Recommendation Report for Listed Building Consent for Alterations, Extension or Demolition of a
Listed Building

REF NO: EG/64/18/L

LOCATION: Flint House
Church Lane
Eastergate
PO20 3UR

PROPOSAL: Listed building consent for internal alterations to include removal of dividing wall between kitchen & dining room, exposing existing timber frame within wall; levelling of internal ground floor & raise front door lintel.

DATE	JULY 2018	DRAWN	TW
DRAWING NUMBER	17123-03	REVISION	*

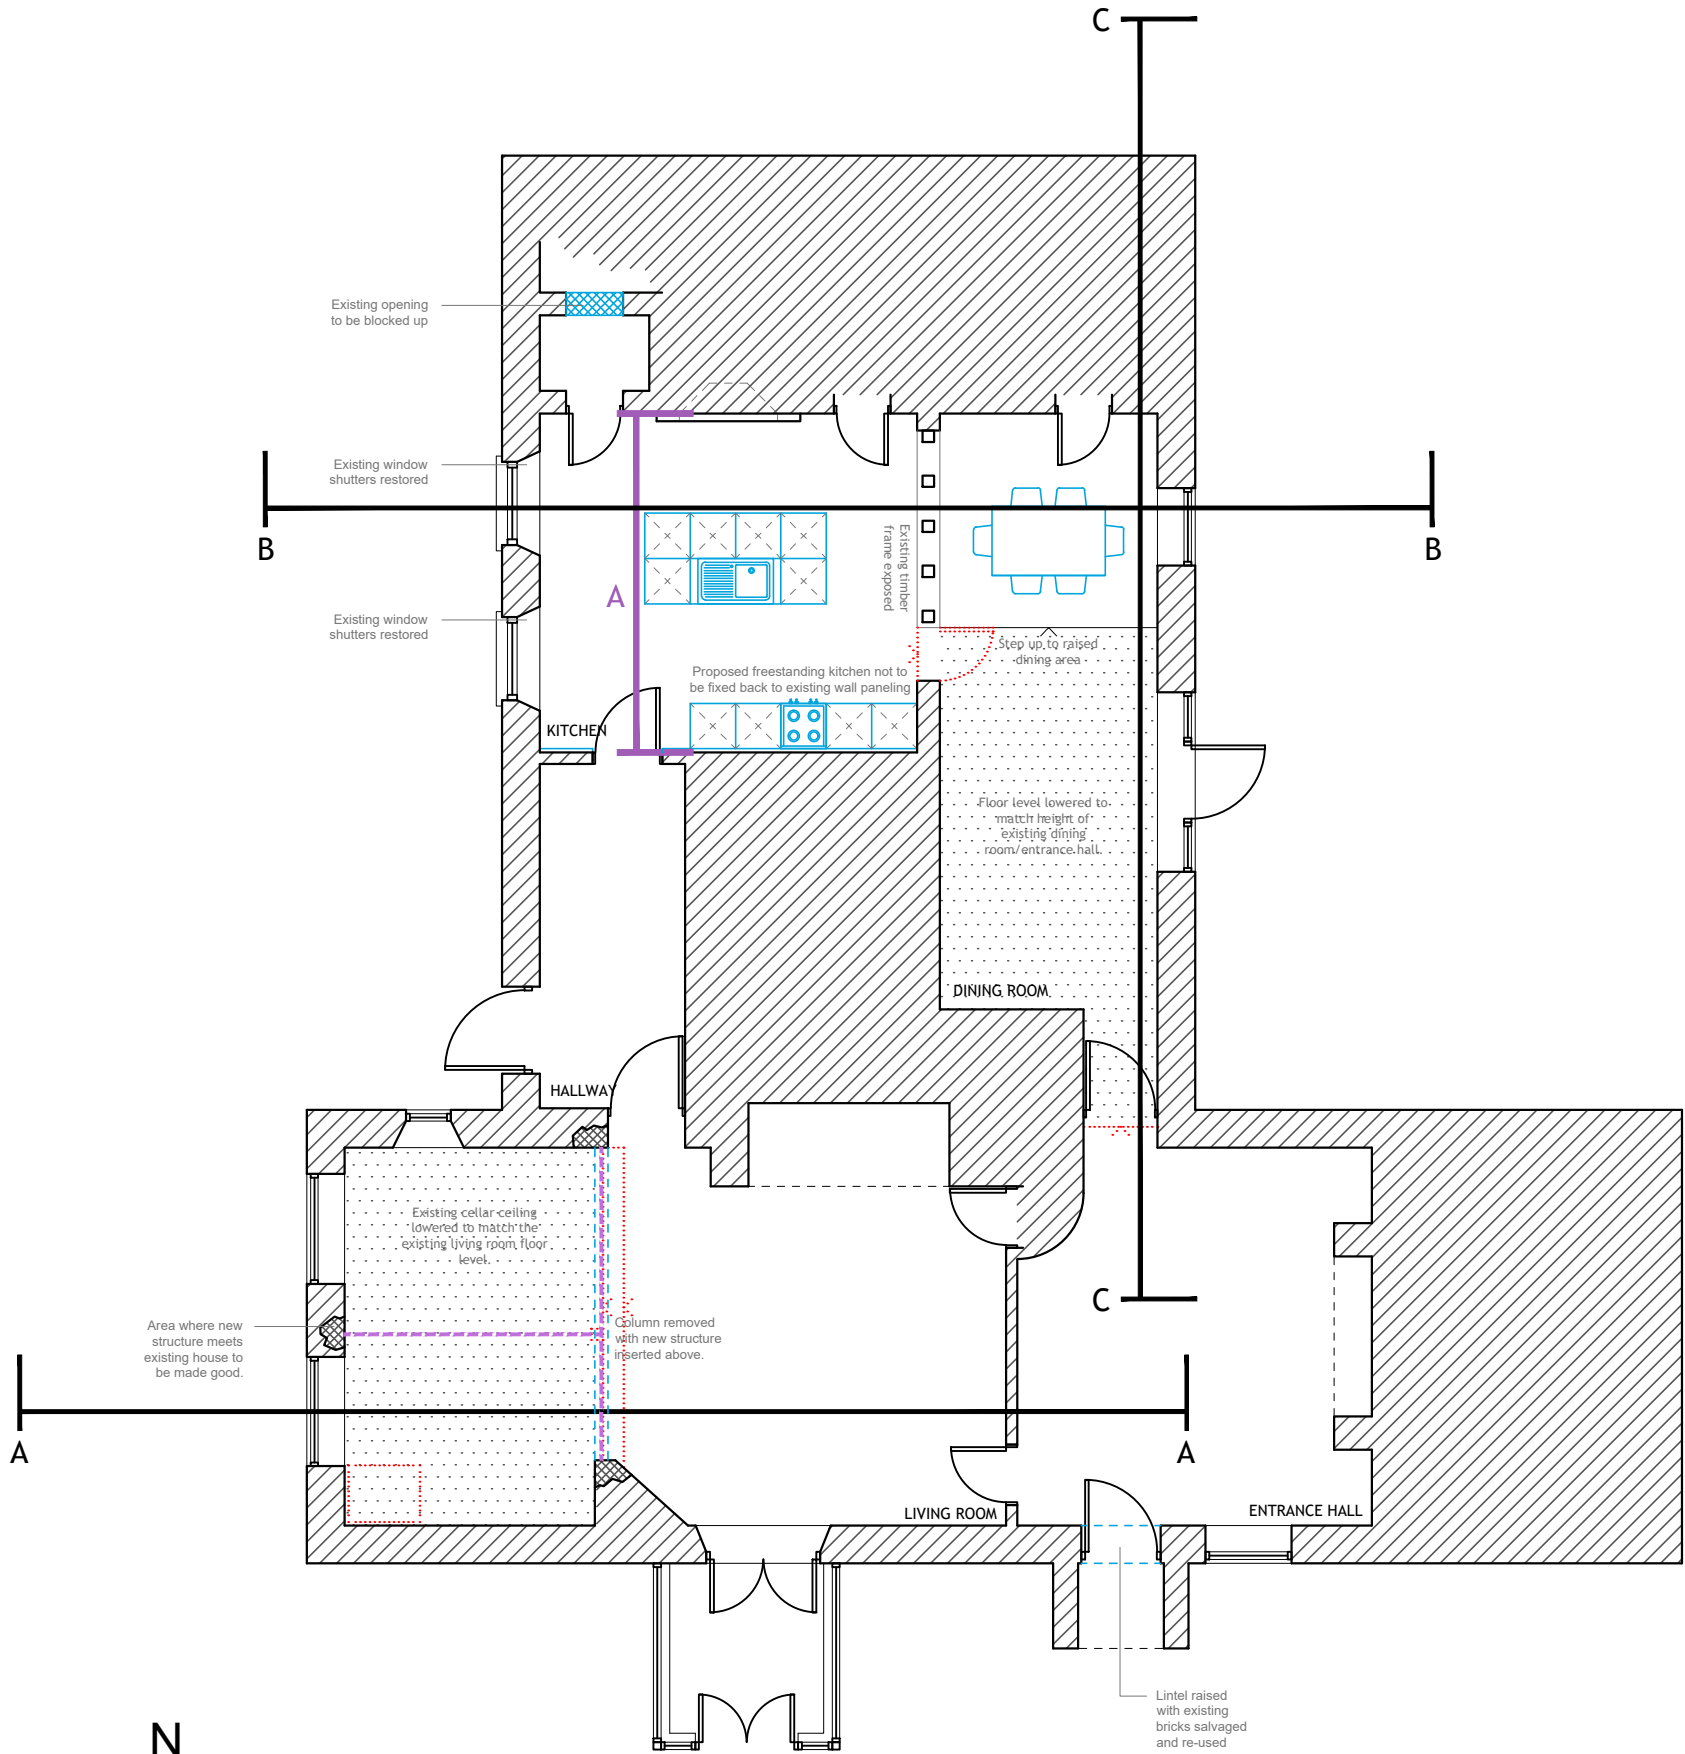
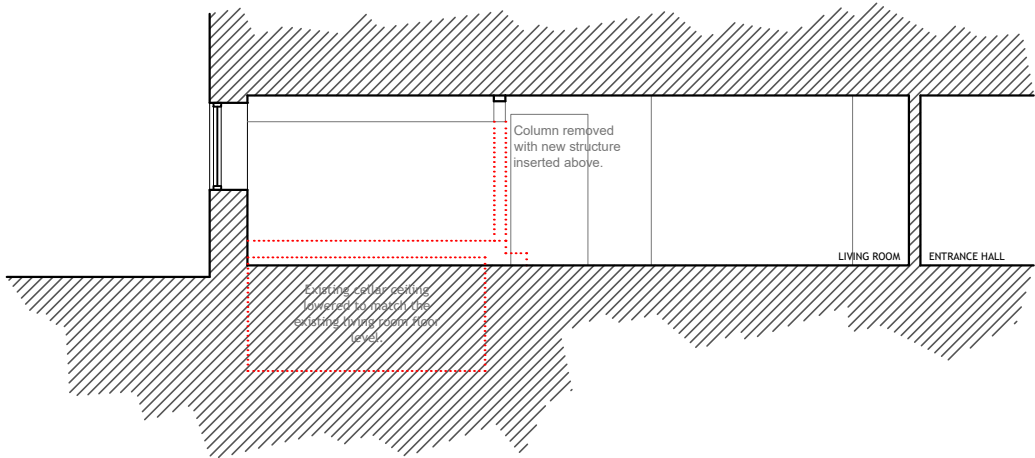
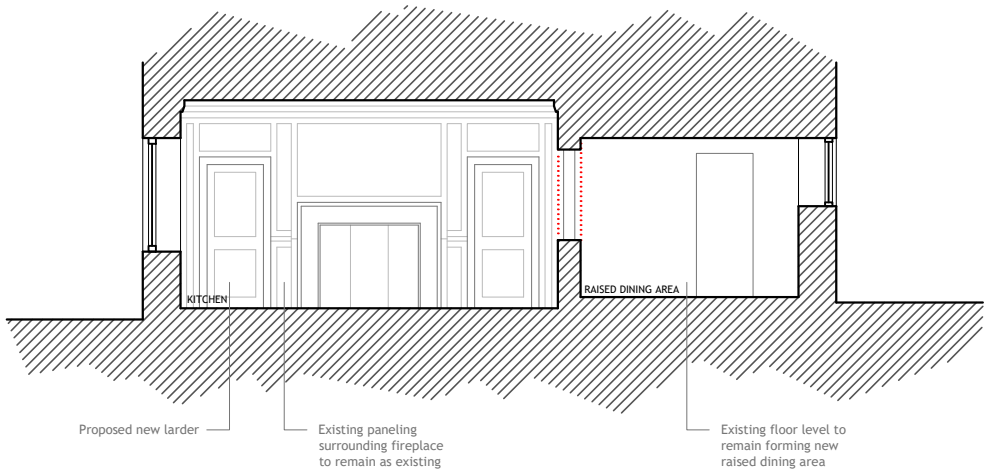
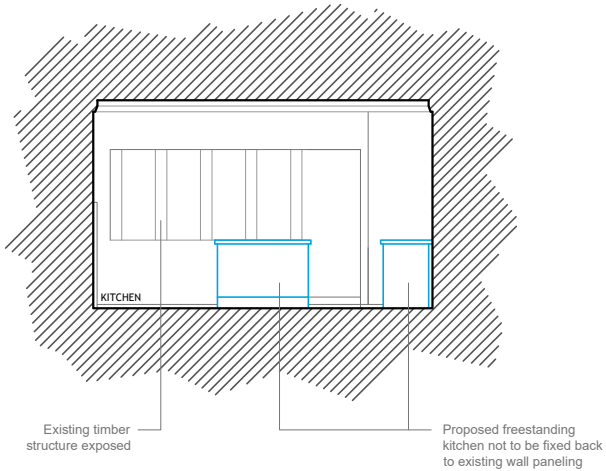
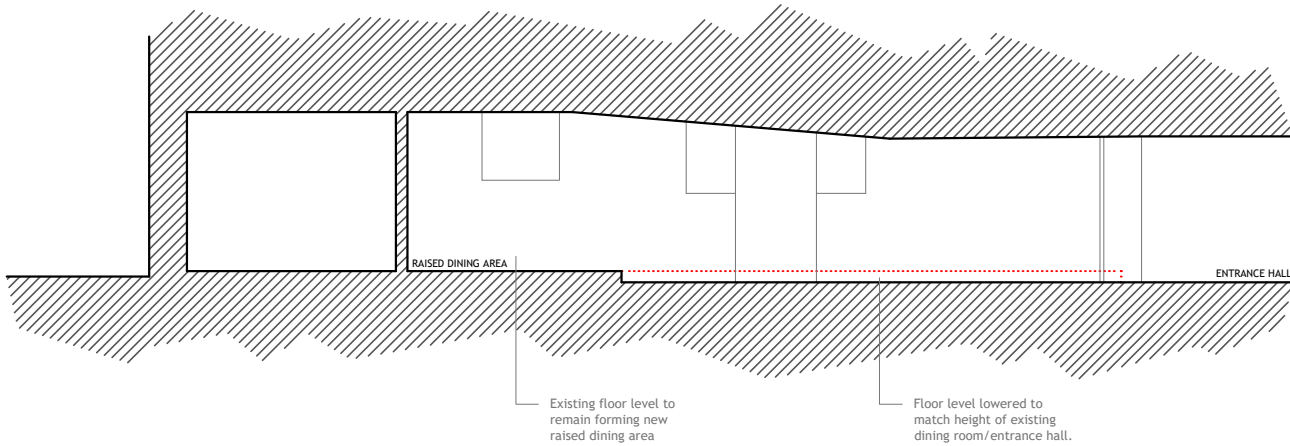
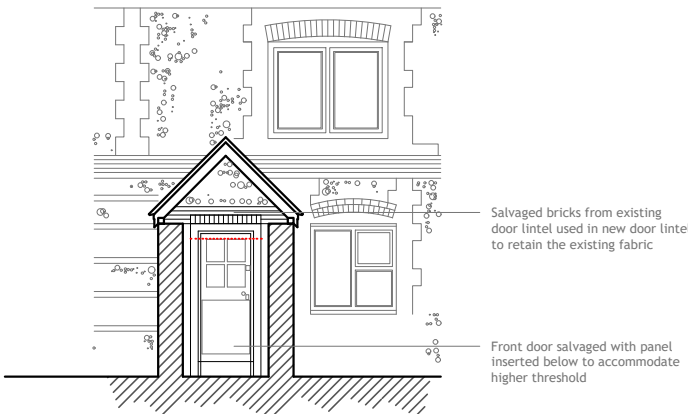
Cellar: the proposal is to return the floor to the original height so that it reflects the rest of the room. Such a proposal is acceptable as it allows the room to be fully used, and restores it more to its previous appearance.

Kitchen/dining room: this proposal allows for the main structural element of the property to remain, whilst allowing the two rooms to be linked. All of the proposed kitchen cabinetry should be free standing so that it does not affect those walls with panelling. The creation of a new larder is also considered to be acceptable.

Kitchen floor: there is a mixture of levels in the property. The proposal will allow for the room to be fully used. I should stress that I am not a structural engineer, and I cannot comment on the impact of the proposed works on the structure of the building.

Front door lintel: the proposal to raise the height of the door is acceptable, as previous alterations have taken place at this point. All of the bricks that are removed should be re-used at the property. I support the retention of the front door, which should be sensitively adapted.
